**CITY OF ALBUQUERQUE  
PLANNING DEPARTMENT  
October 7, 2015  
DRB Comments**

**PROJECT # 1009506**

**RE: Units 6 & 9, Volcano Cliffs**

DESCRIPTION OF REQUEST: Sketch Plat Review for Montecito West Phase 2

SKETCH PLAT FOR
 MONTECITO WEST UNITS 5 & 6
 BEING A REPLAT OF
 TRACT 7, MONTECITO
 WEST UNIT 3 & 4

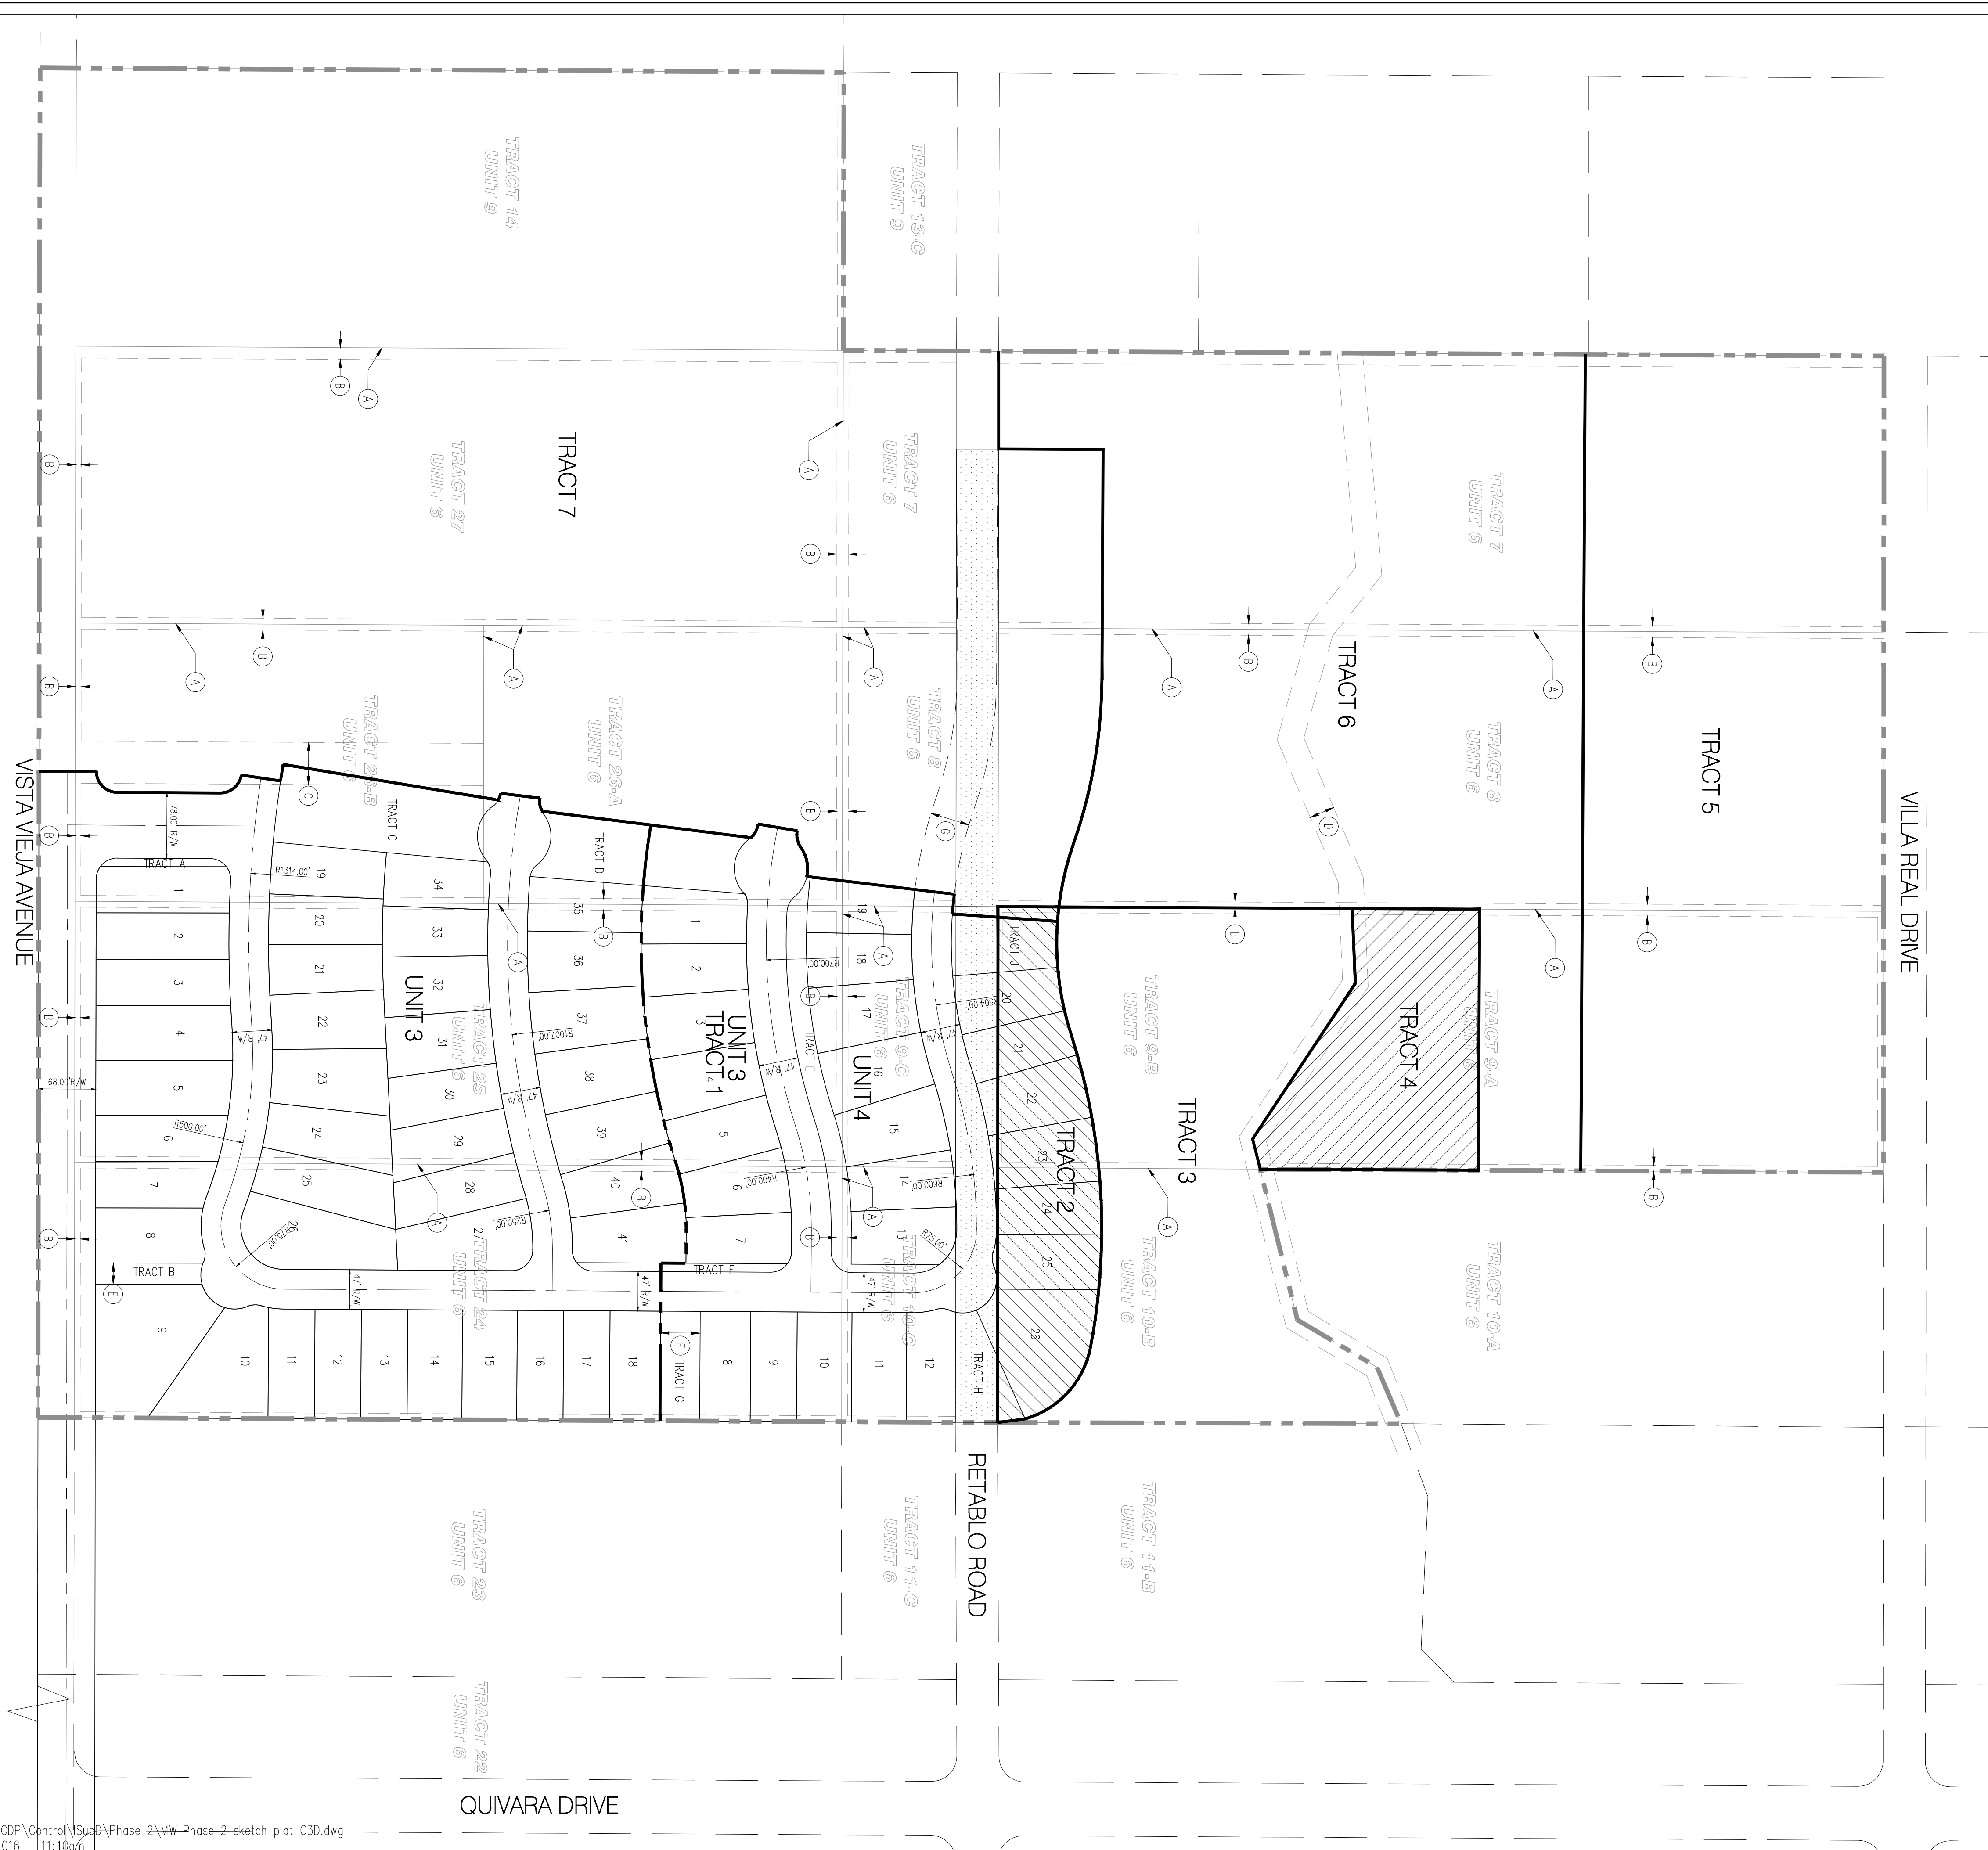
Connectivity with adjoining property needs to be addressed.

Traffic calming (bump outs/ roundabouts) should be considered adjacent to proposed Tract D given the length of that tract's block.
